From: Tom Wessely [REDACTED]
Sent: 26 August 2021 17:19
To: Simon Davis <Simon.Davis@arun.gov.uk>
Cc: David West [REDACTED] Andy Mckeown-Mundy [REDACTED]
[REDACTED] Ian Johnson [REDACTED]
Subject: Re: Condition 5 ref. Y/97/21/DOC , Condition 6 ref. Y/103/21/DOC, and Condition 9 ref. Y/99/21/DOC

With regards to Condition 5 and on behalf of my client, Seaward Properties Ltd, I can confirm that the windows will be installed as per the previous plan i.e. recessed so as to create the shadow line.

Typical detail
Window head sill and jamb
in brick elevation

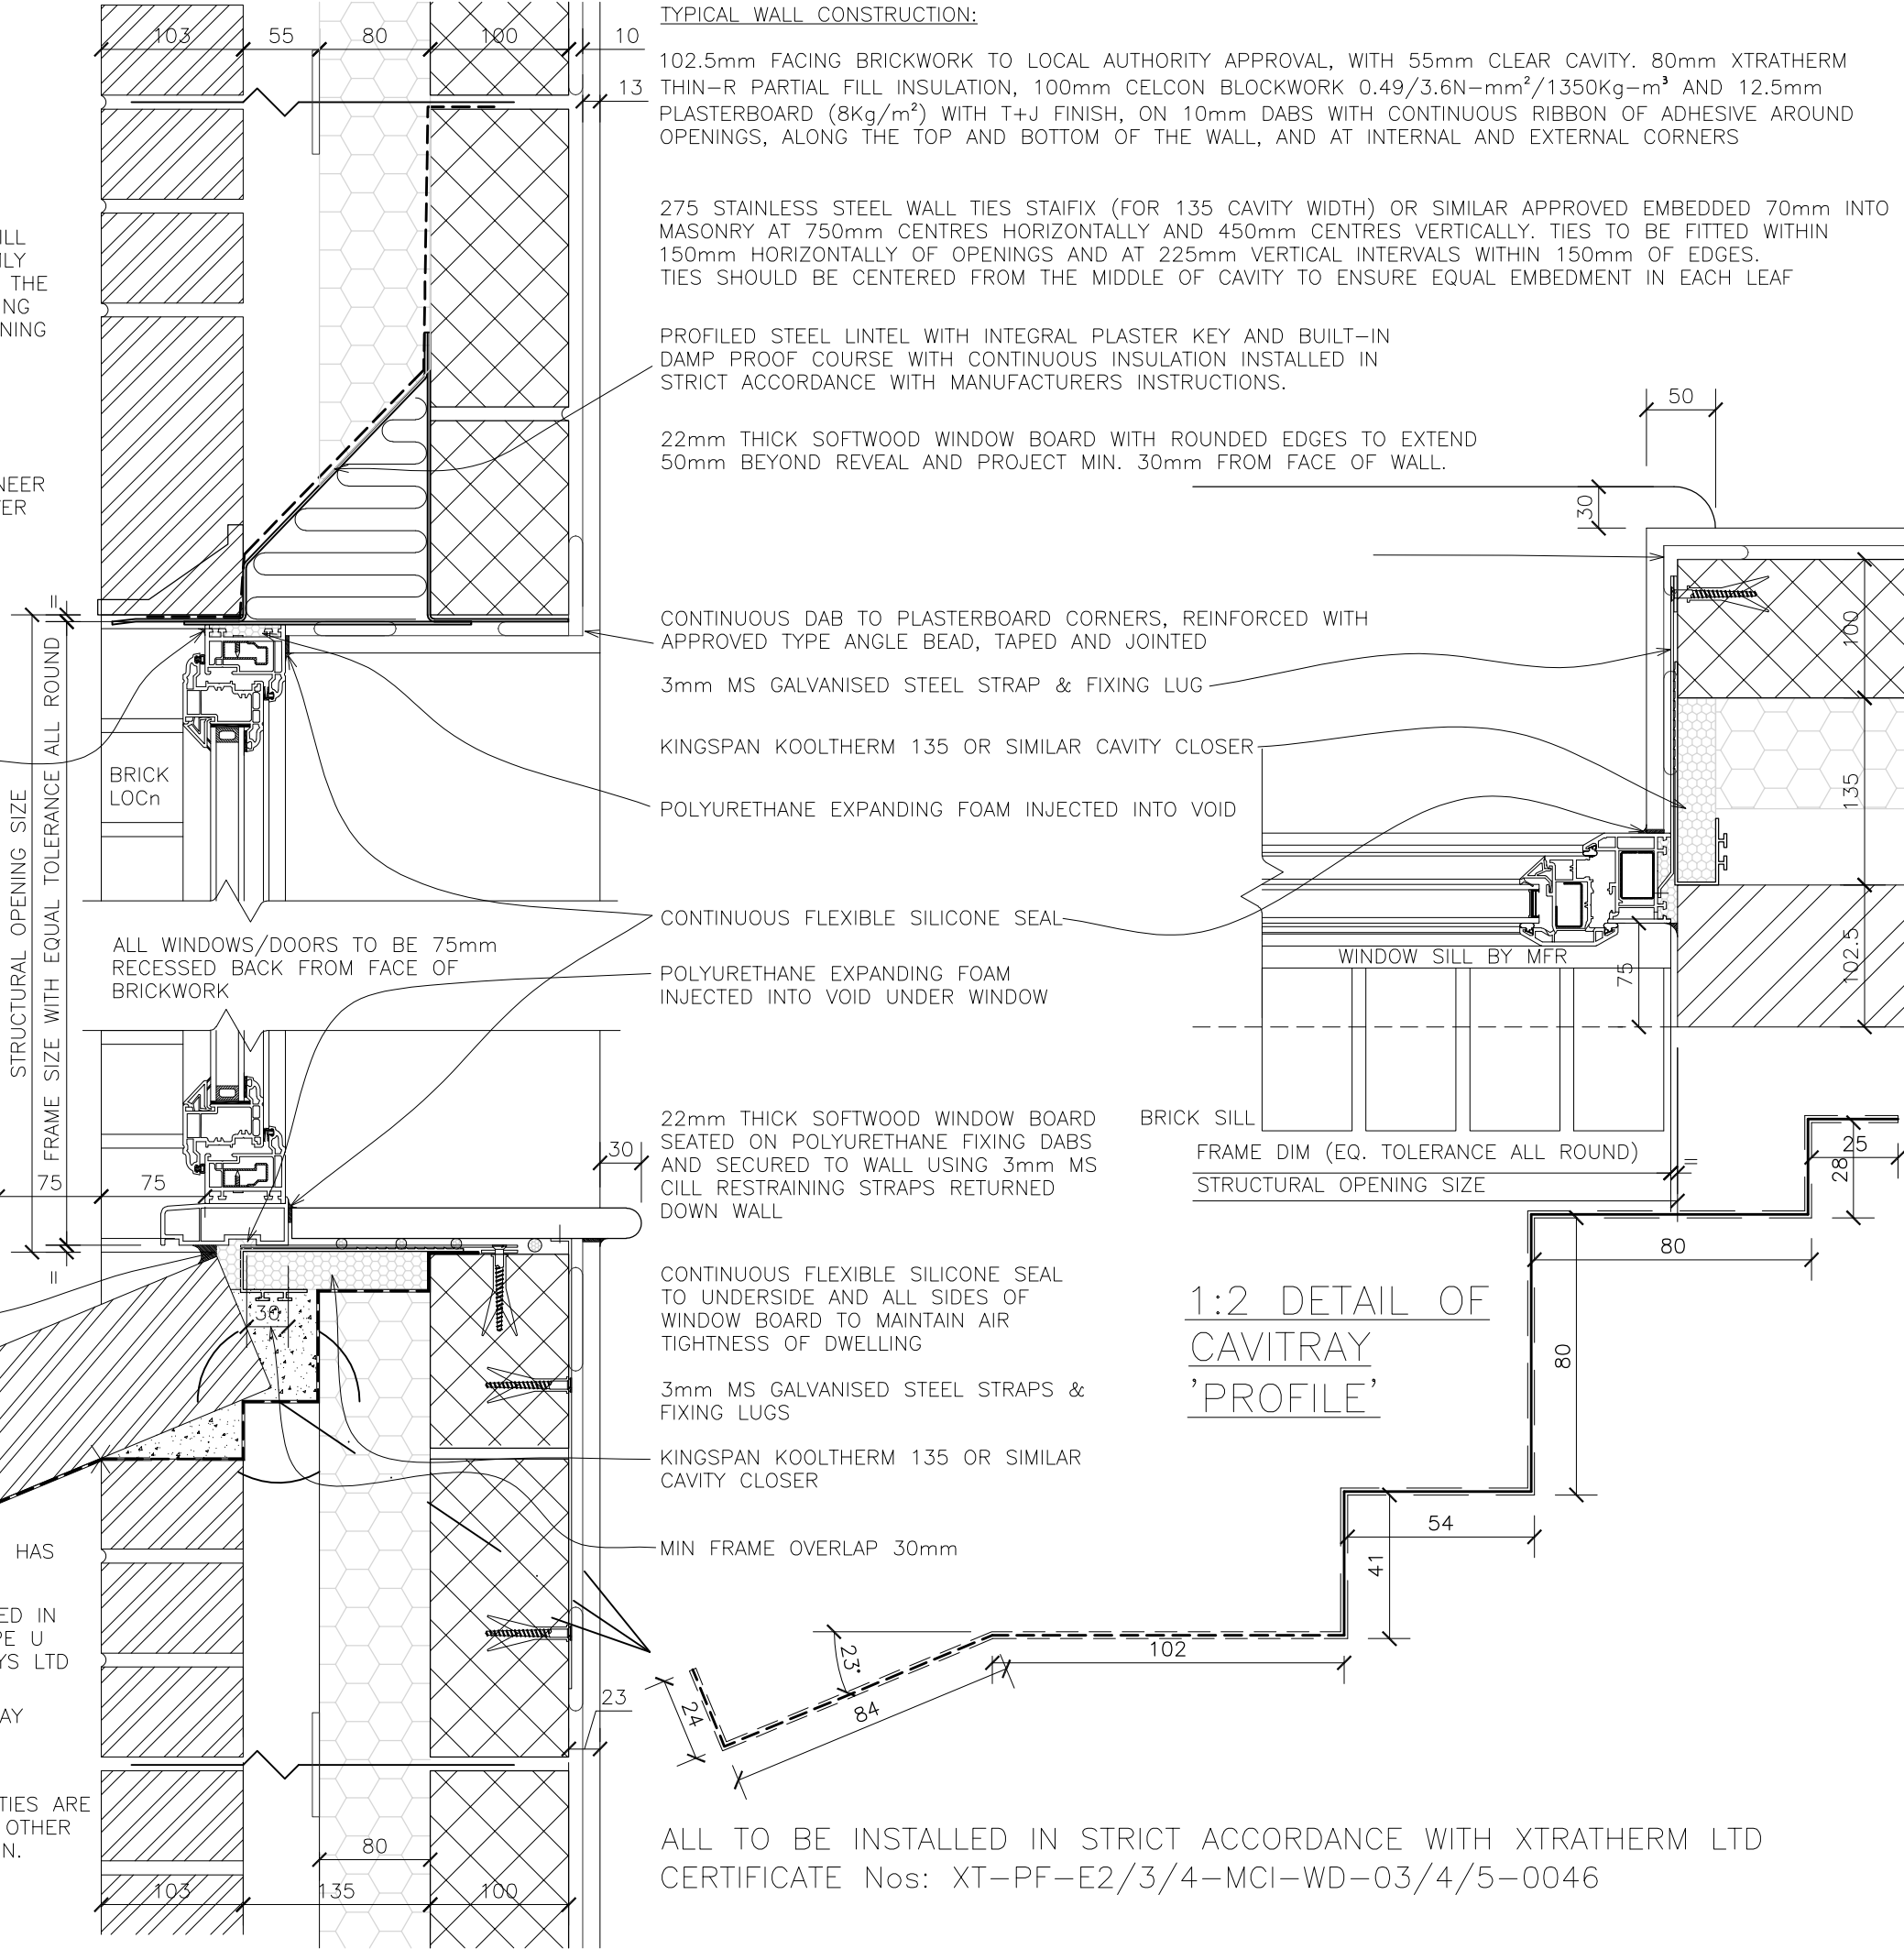
Martyn responded yesterday to say that he thinks the windows look to be fine. He asks that you confirm that they will be installed as per the previous plan i.e. recessed so as to create the shadow line. Please confirm.
